Proposed Royal Randwick Racecourse Hotel SSD 5002-2011 Preferred Project Report Statement of Heritage Impact

This Statement of Heritage Impact has been prepared to accompany the Preferred Project Report (PPR) for State Significant Development (SSD) 5002-2011, the Royal Randwick Hotel.

This letter format report discusses the heritage related issues raised in correspondence from the Department of Planning and Infrastructure (DPI), dated 17 September 2012, in the context of the design revisions. The DPI comments are noted below in bold italics.

DRAWING NO A-9001	REVISION B

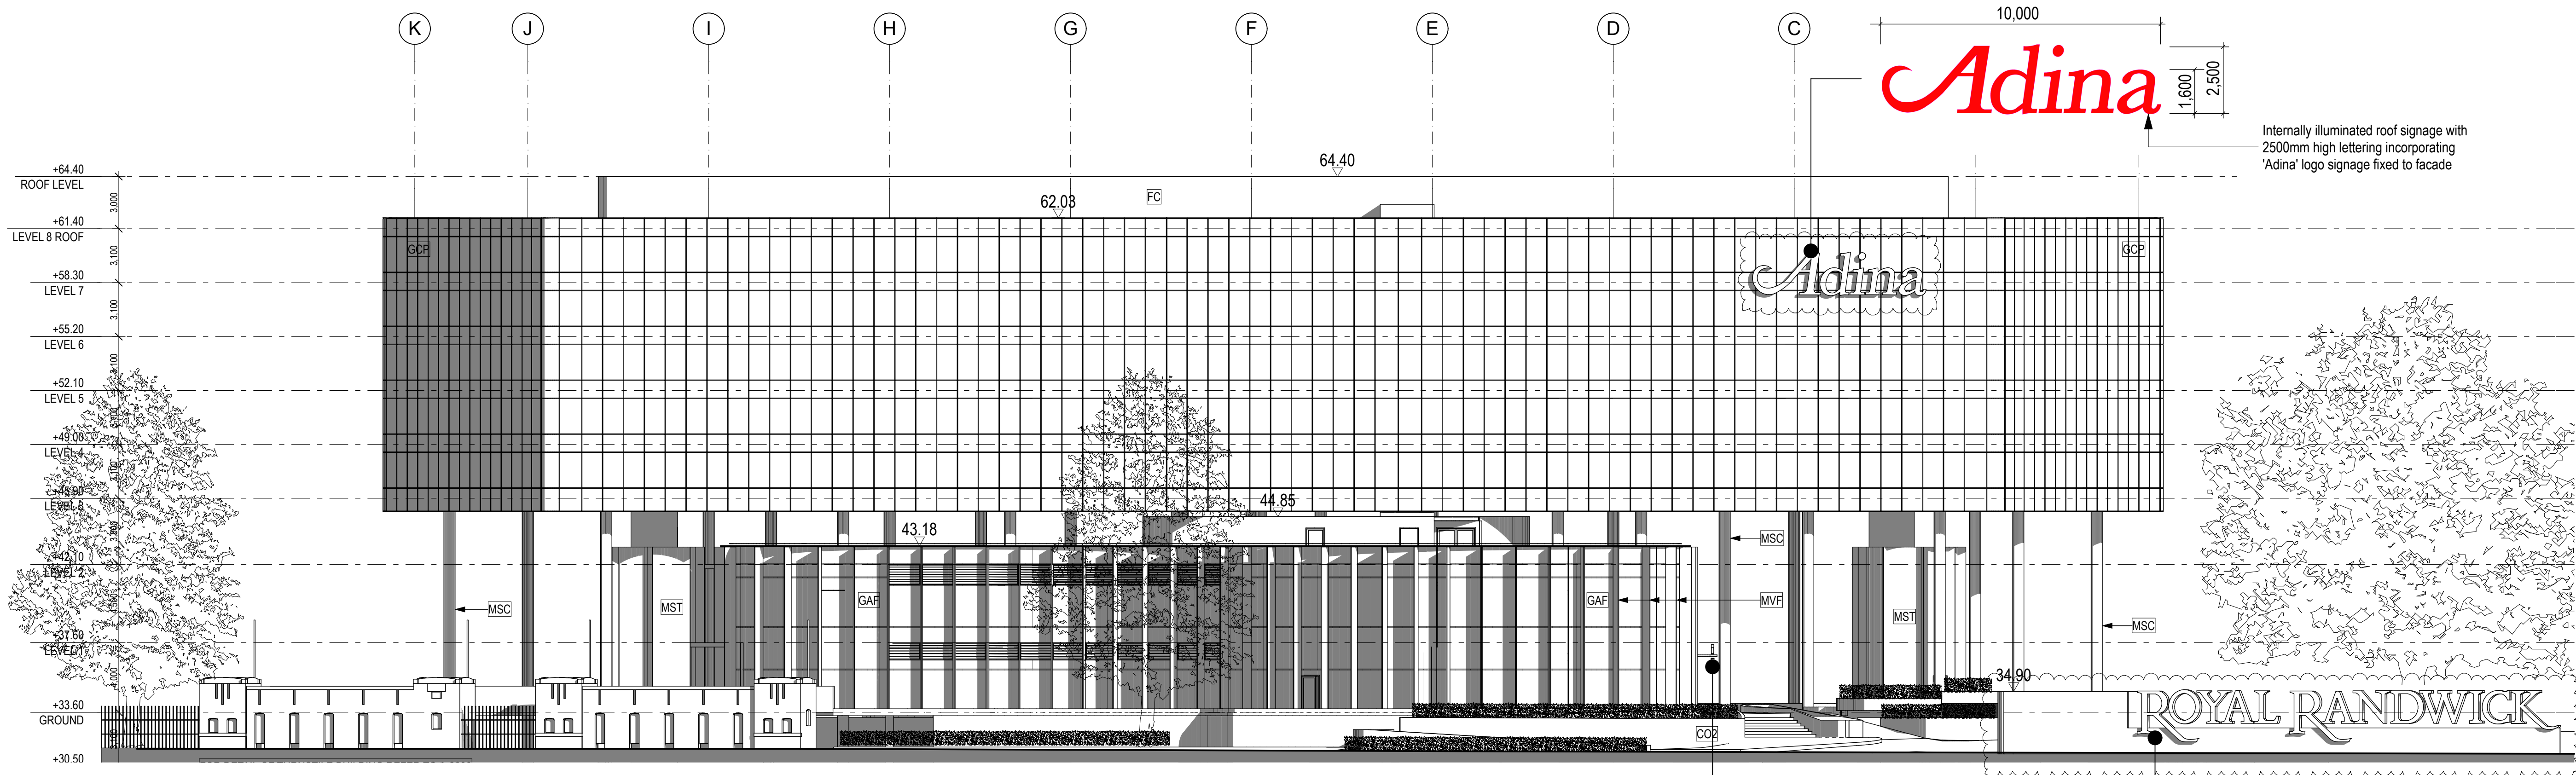
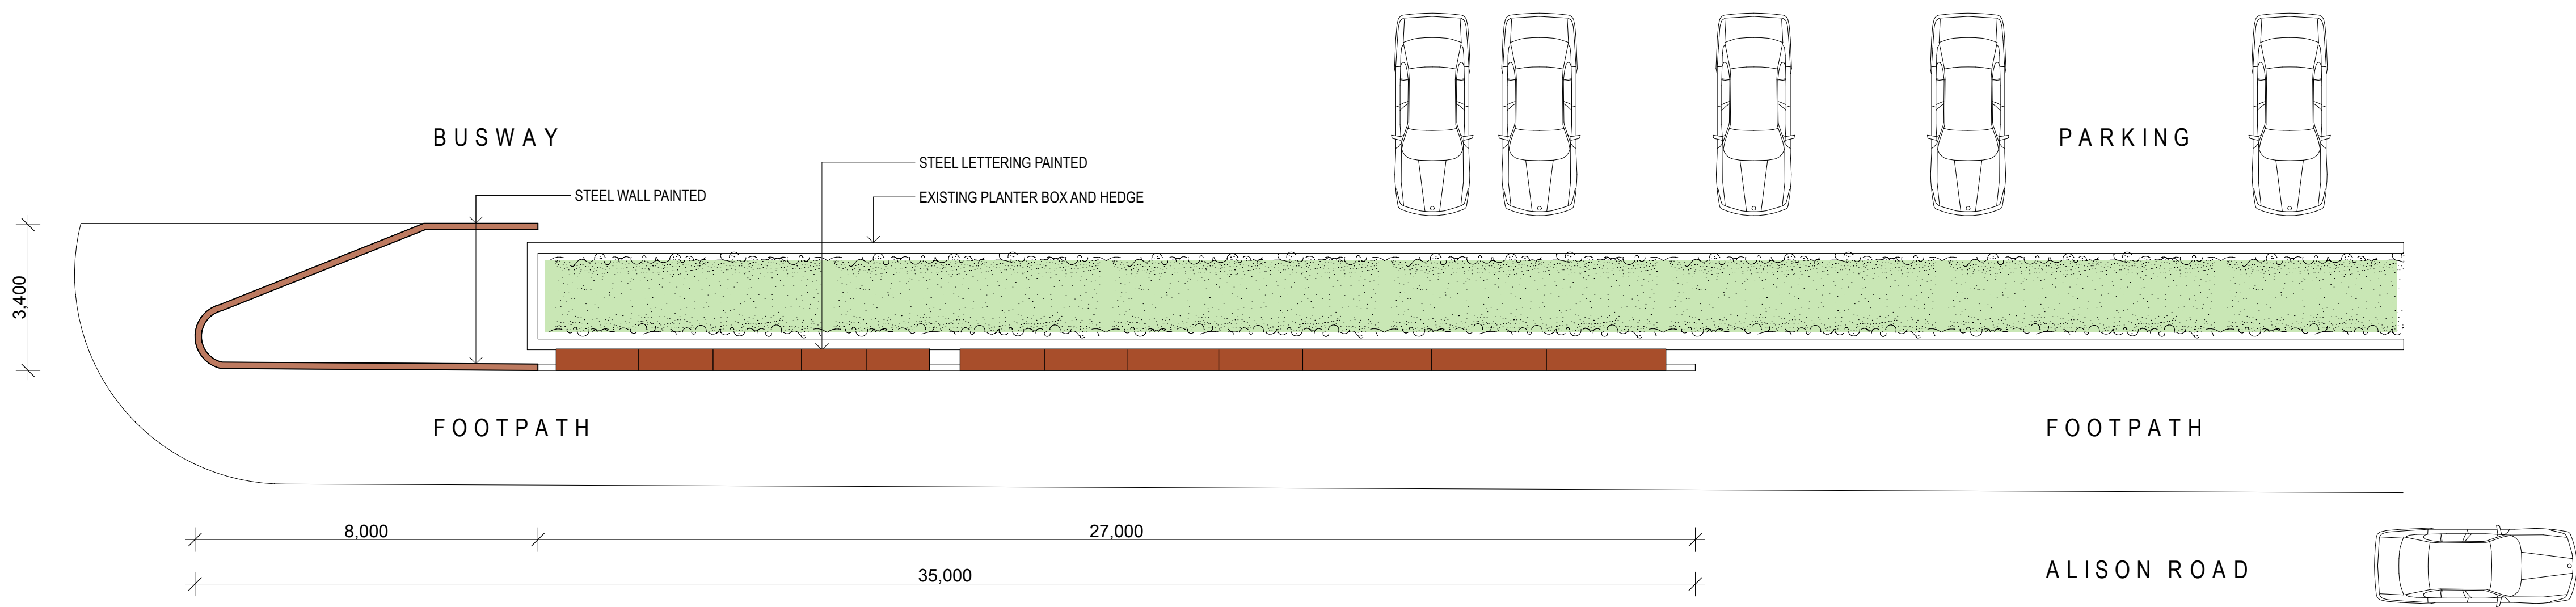
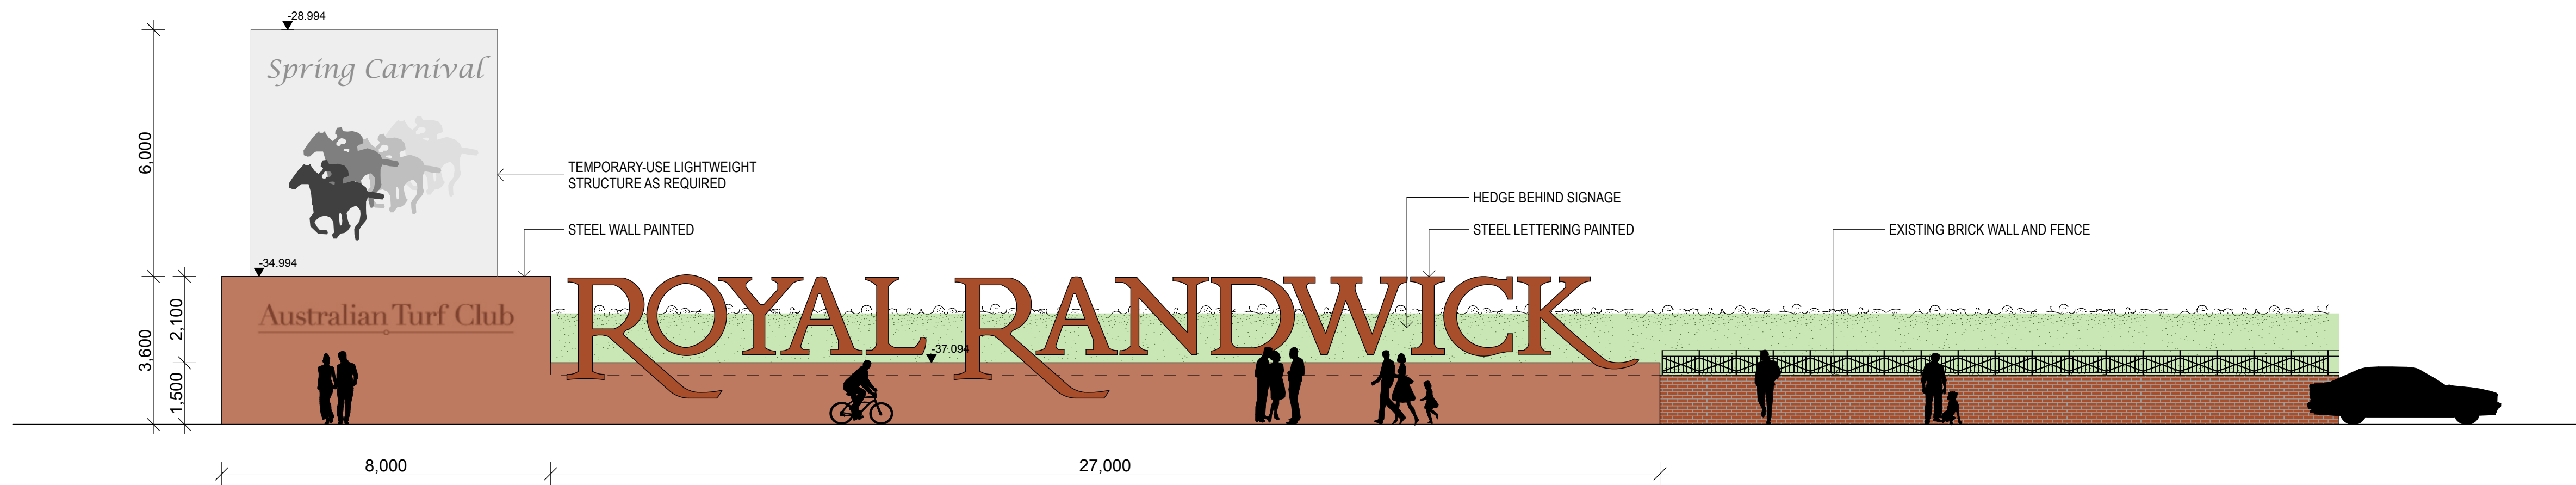
- ***An assessment of the proposed signage against relevant sections of the NSW Heritage Office's (now Branch) publication 'Statements of Heritage Impact' should be provided.***

The signage, proposed as part of the Project application, includes internally illuminated identification signage at roof level on the north and south elevations of the building, the car park entrance and the main entrance to the hotel, within the Royal Randwick Racecourse site. The PPR signage has been revised to reduce and relocate the roof level signage and to include site identification signage on Alison Road. This has been designed to replicate the dimensions and colour palette of the former Turnstile building and to frame the hotel building.

The impact of the new signage on the heritage significance of the Racecourse Precinct Heritage Conservation Area has been minimised by separating the 'Royal Randwick' site identification sign, and the 'Adina' hotel sign. This reinforces the primary importance of the racecourse site.

The revised signage proposal has two components proposed; the 'Adina' signage is to be located on new, infill hotel building, not on any site components of exceptional or high significance. The specific guidelines for signage, in this publication, are applicable to signage on listed heritage buildings, not infill buildings such as the proposed hotel.

The proposed signage is an integral part of the building and will not, in itself, visually dominate the Racecourse Heritage Precinct Conservation Area, or the adjacent Official / Members Stand.

While internally illuminated signage may not be appropriate on some listed heritage buildings this is not the case for this application. As the proposed signage is for a new built element of contemporary design internal illumination is considered to be acceptable.

TURNSTILE BUILDING GROUND PLAN

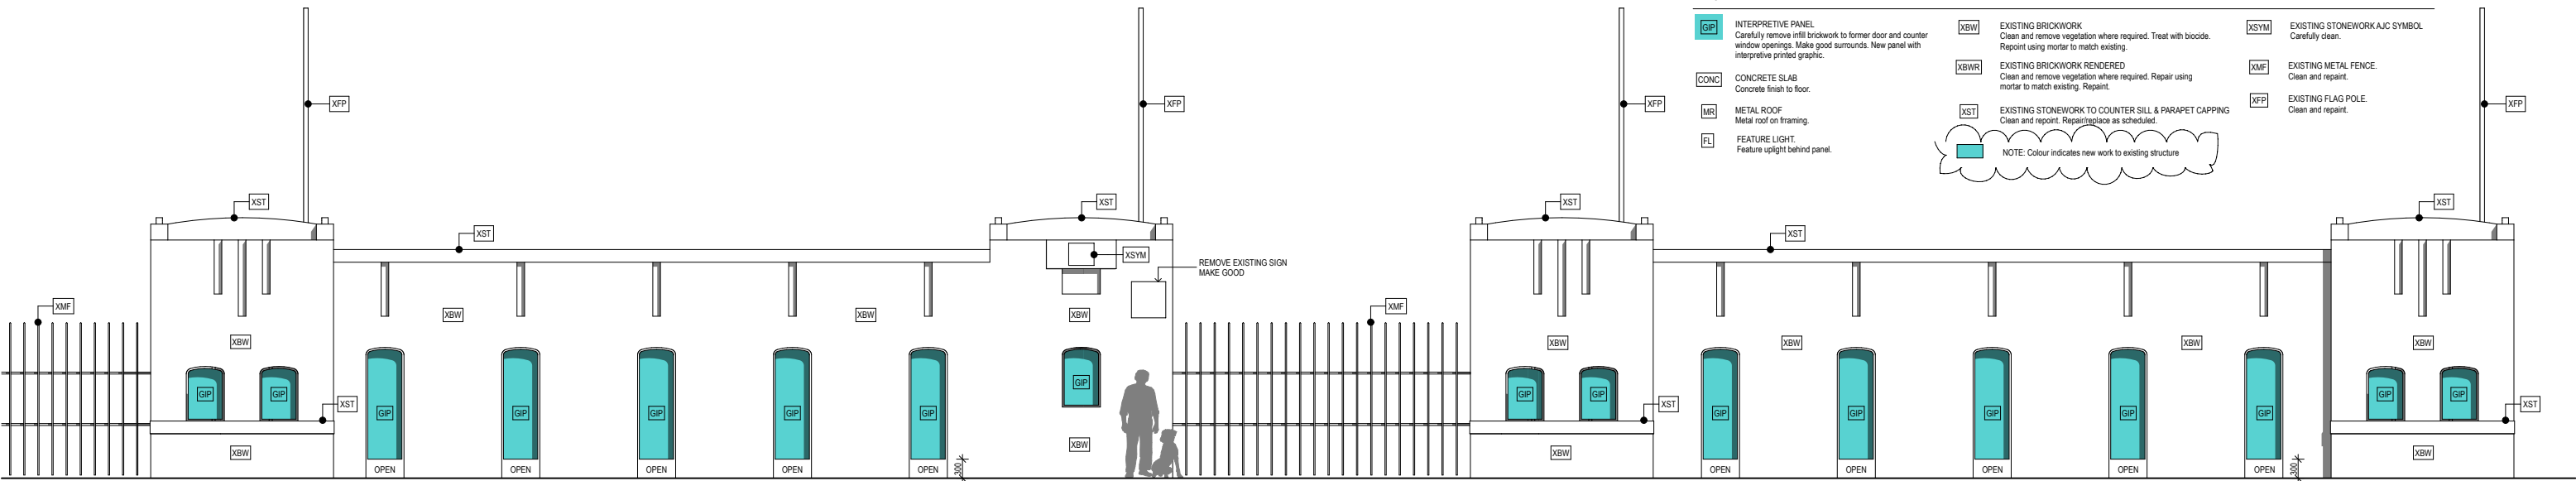
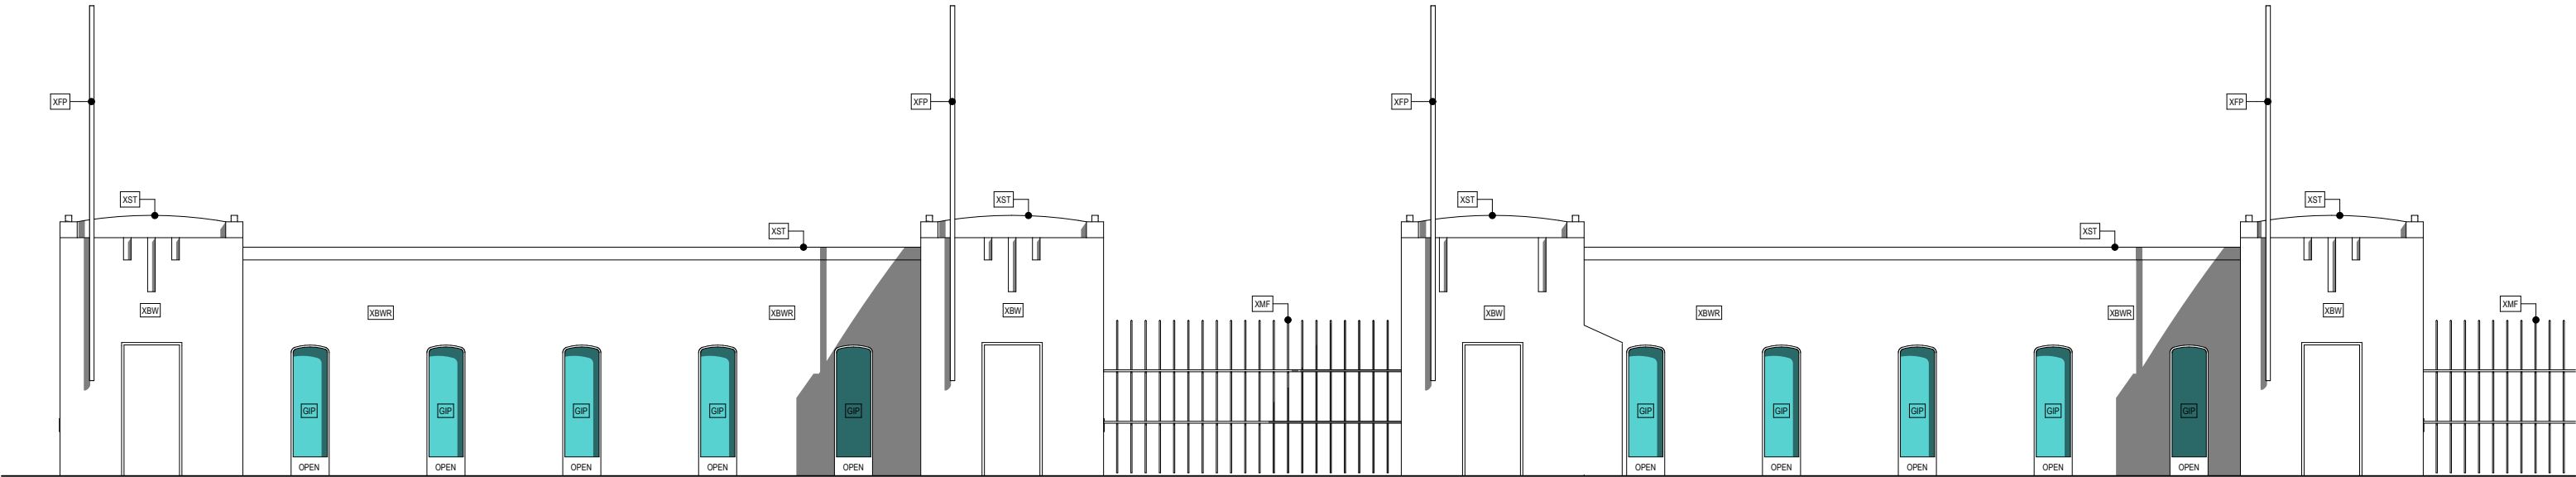
- ***details of the proposed interpretation panels to the Turnstile building, including how they relate to the Godden Mackay Logan Conservation Management Plan, what information is to be displayed.***

Godden Mackay Logan prepared the *Royal Randwick Racecourse Interpretation Plan Phase 1 Strategic Overview* report in 2009. Section 6.2 of this Interpretation Plan notes "The original function of the former Turnstile Building at Gate 6 could be interpreted through a trompe l'oeil painting scheme for the surviving elements of ticket windows, numbers and doors to visually interpret its original function.

The interpretation panels proposed in this application are considered to be consistent with the overall strategy for the site. Details of the proposal, including the images to be displayed, is to be yet to be prepared. It is therefore recommended that the project approval include a condition of consent requiring this information be provided to the DPI before the issue of a Construction Certificate.
